Freedom Forever
Planset Revision Letter

11/26/2024
REV #2

RAYMOND PATTERSON
118 OLEANDER LANE

ROOF MOUNT PHOTOVOLTAIC SYSTEM

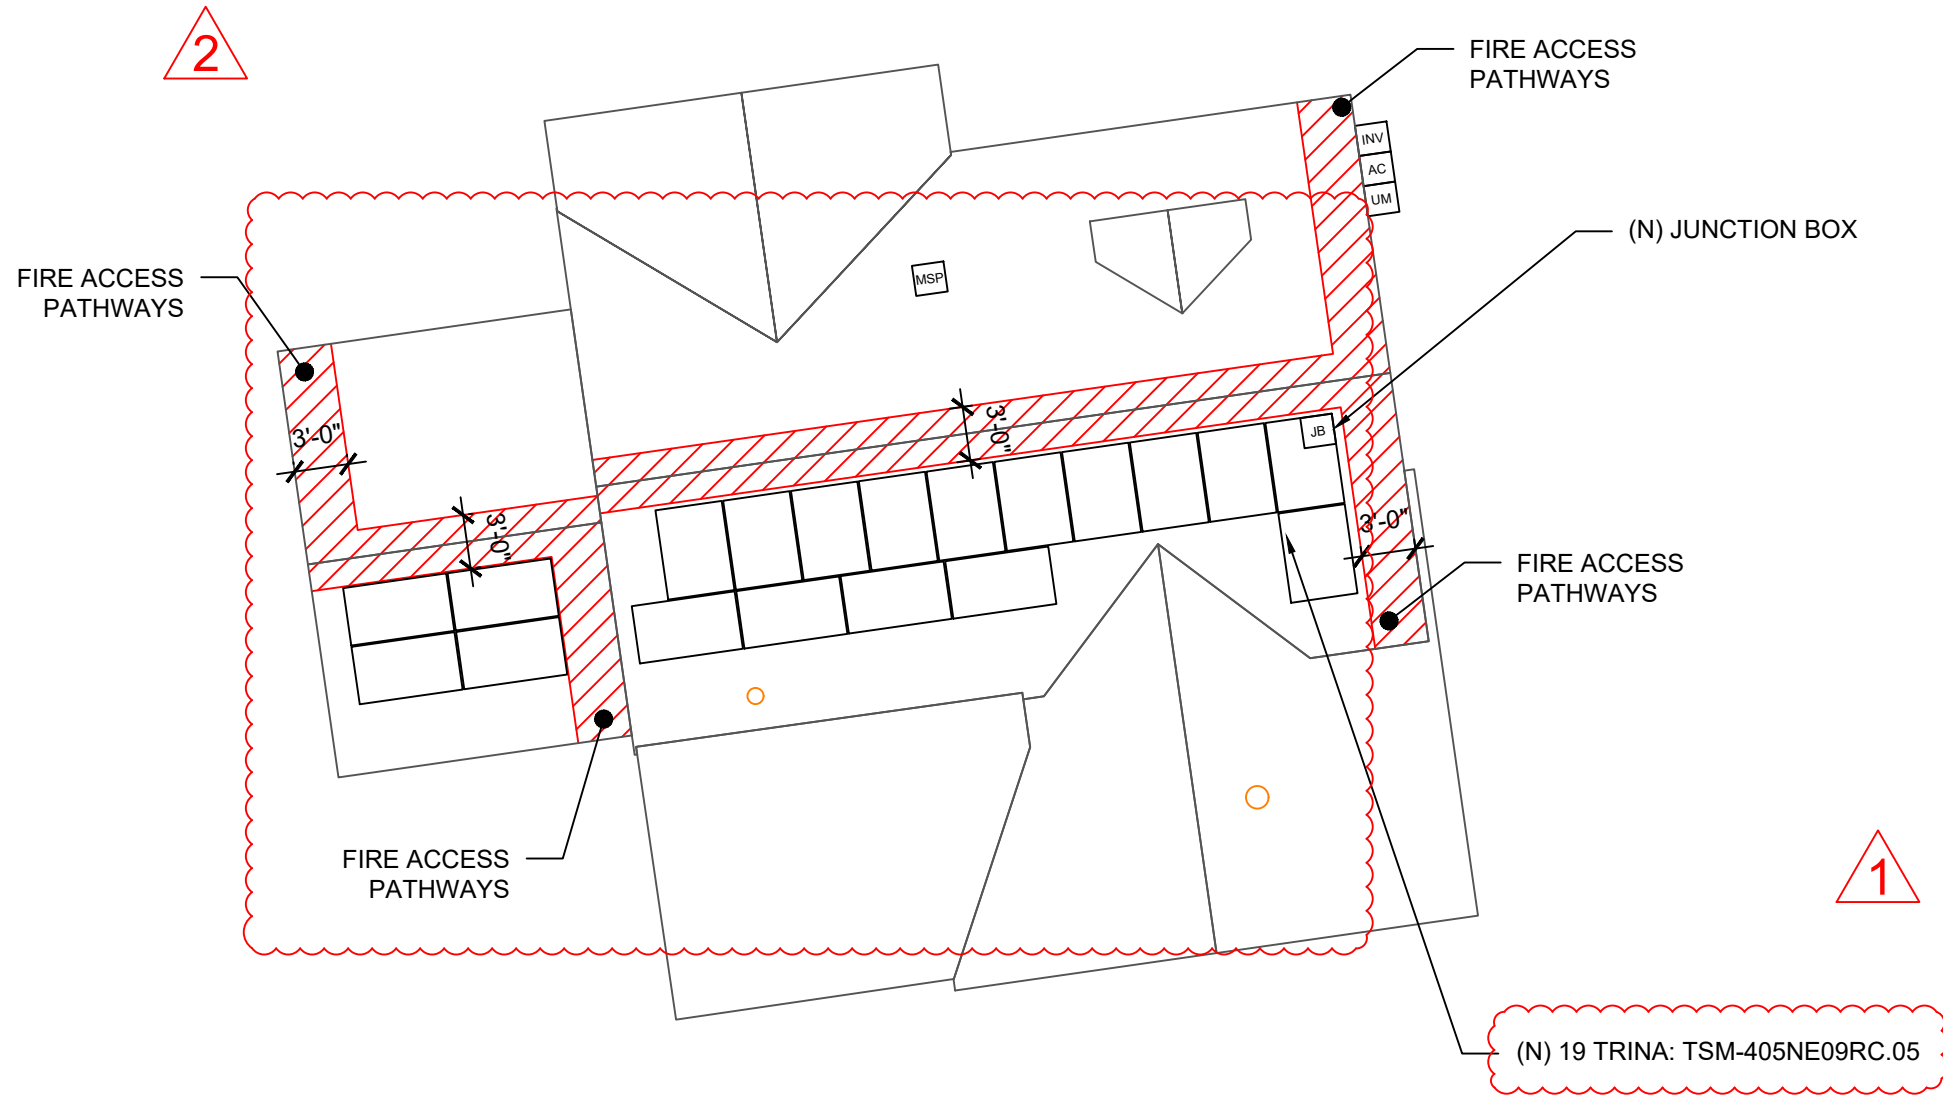
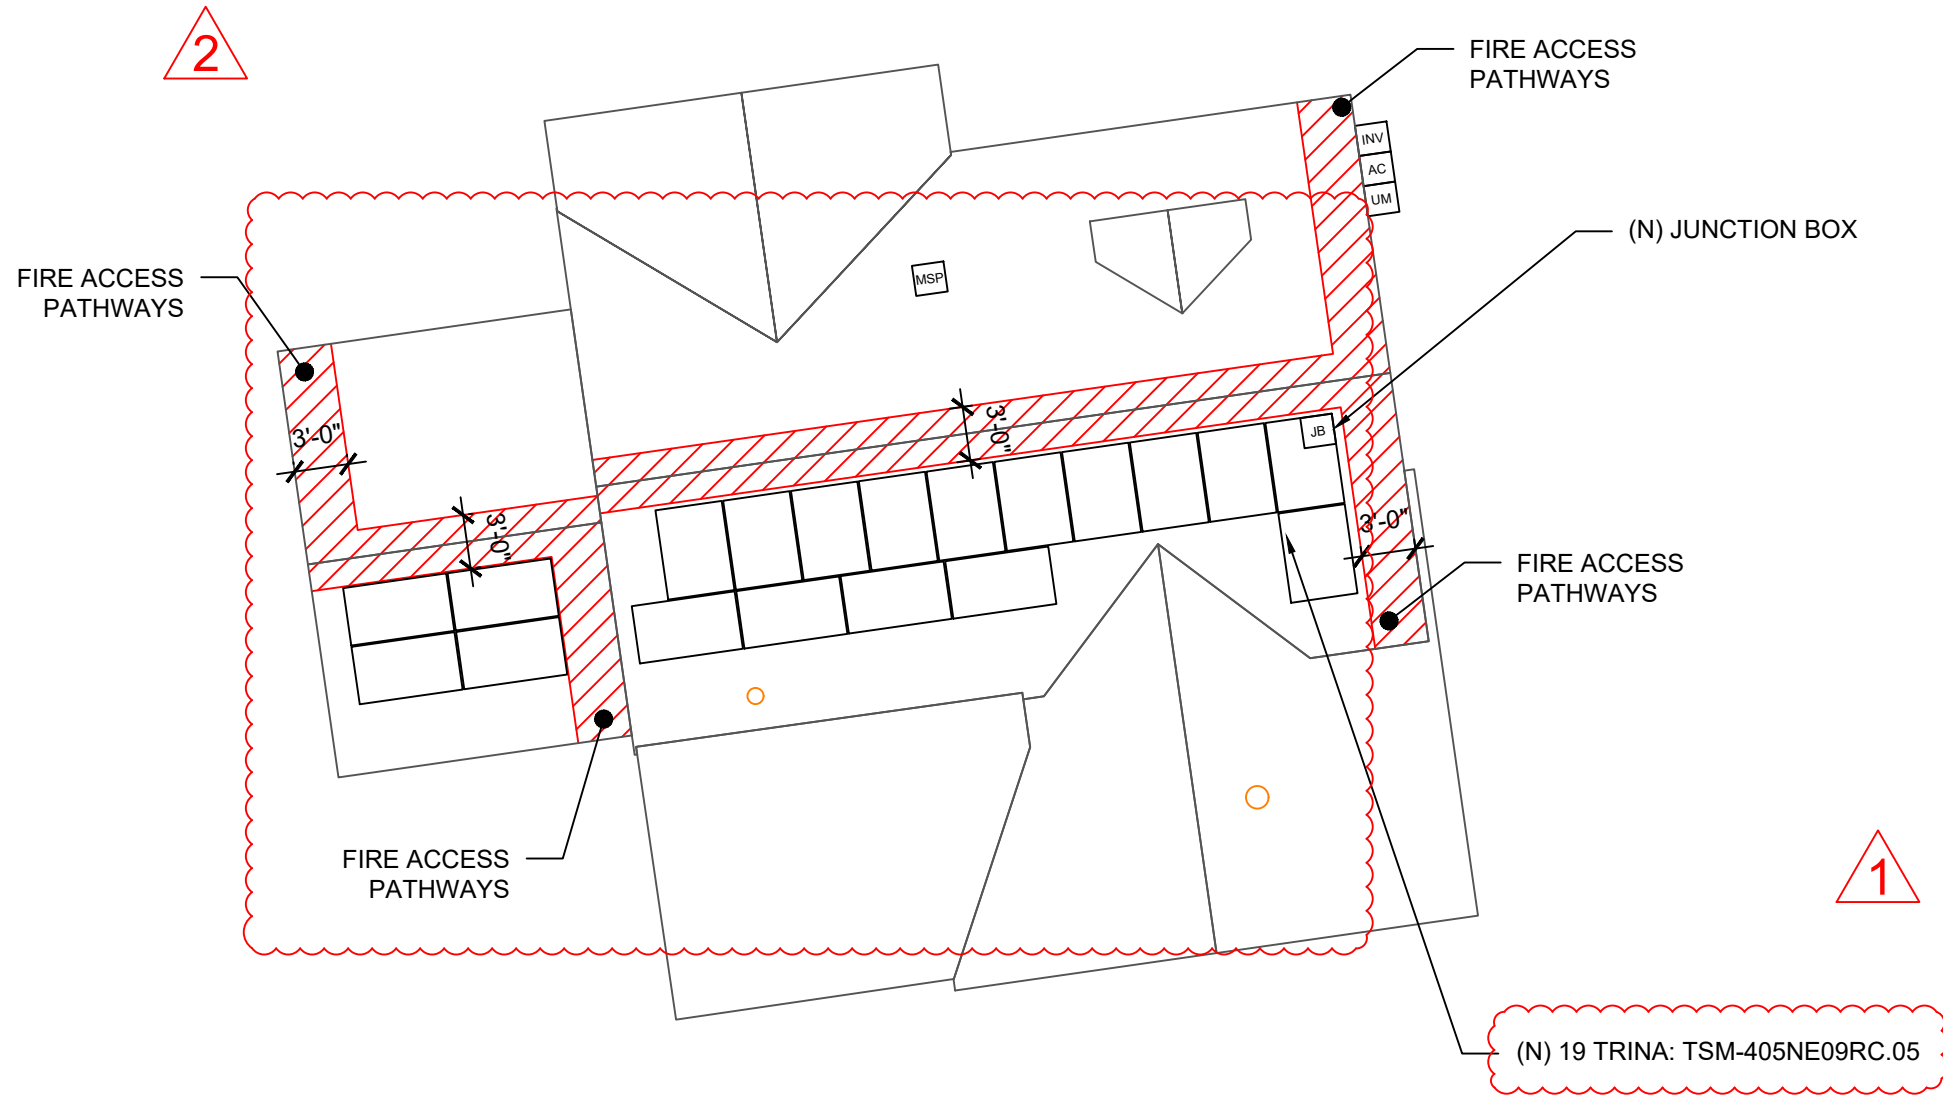
Layout changed as requested.

JOB NO:	DATE:	DESIGNED BY:	SHEET:
495493	11/26/2024	A.P.	PV-1

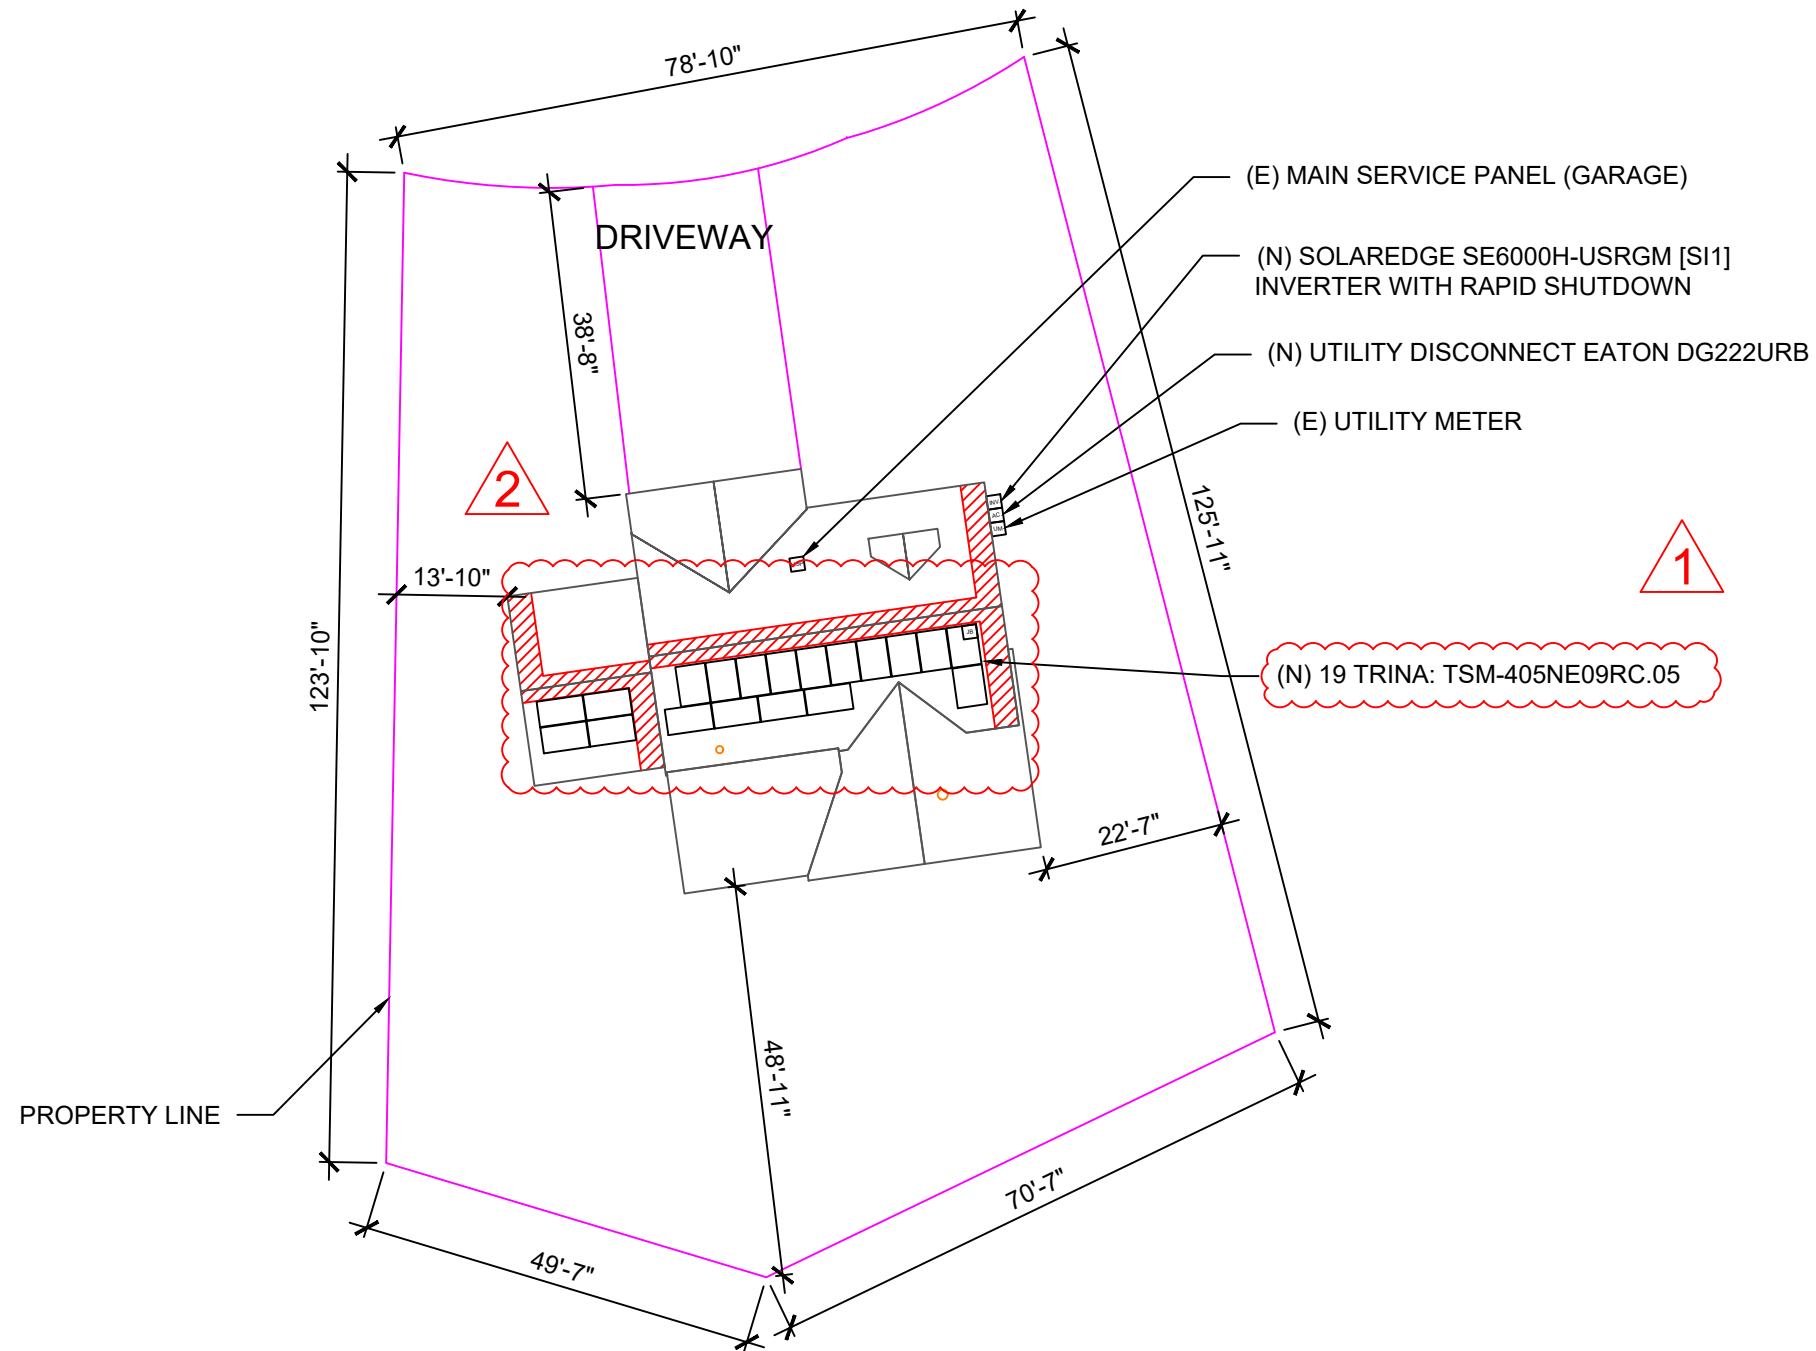
MODULE SWAP SILFAB 430 TO (19) Trina: TSM-410NE09RC.05 AS PER INSTALL
